LSC Responses to EPC TIS Redline Comments

Appendix Figure 1

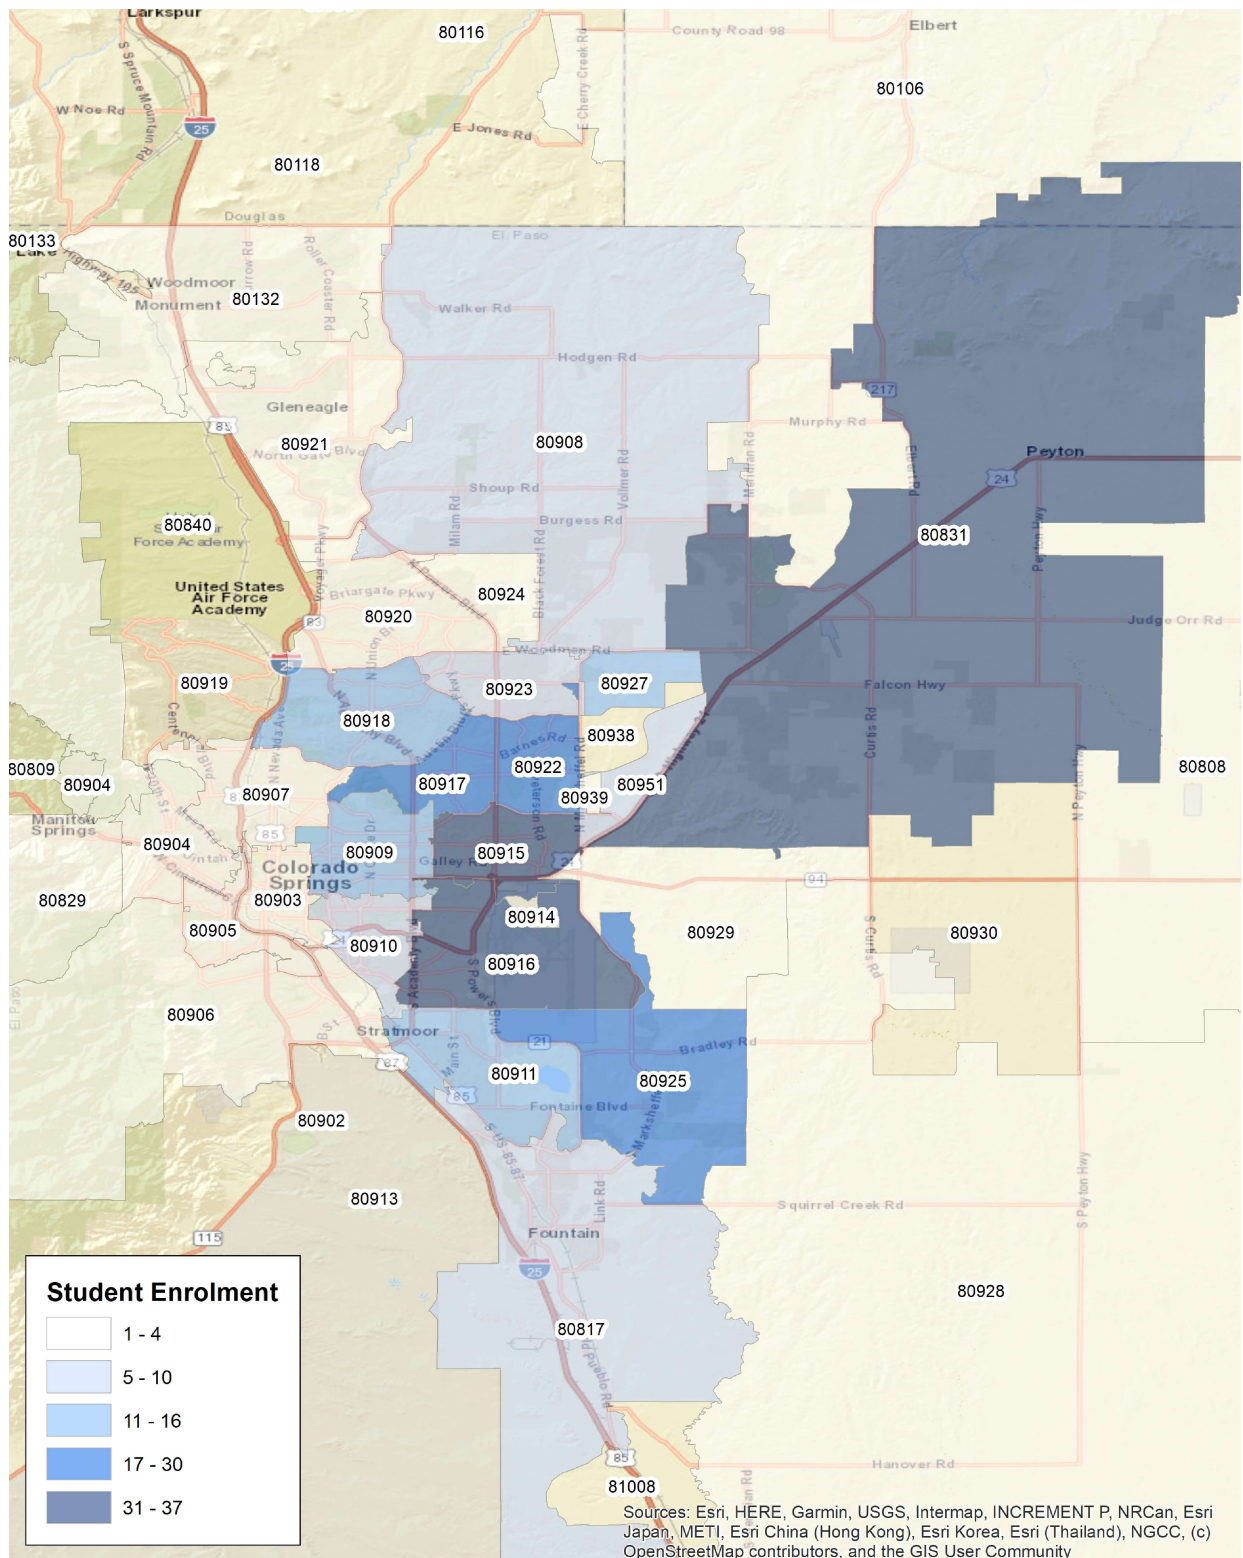
Revise to include zip code information since it is not in the appendix.

Revise to include zip code information since it is not in the appendix.

Author: jchodsdon Subject: Sticky Note Date: 11/2/2022 4:49:57 PM
LSC Response: Included as requested.
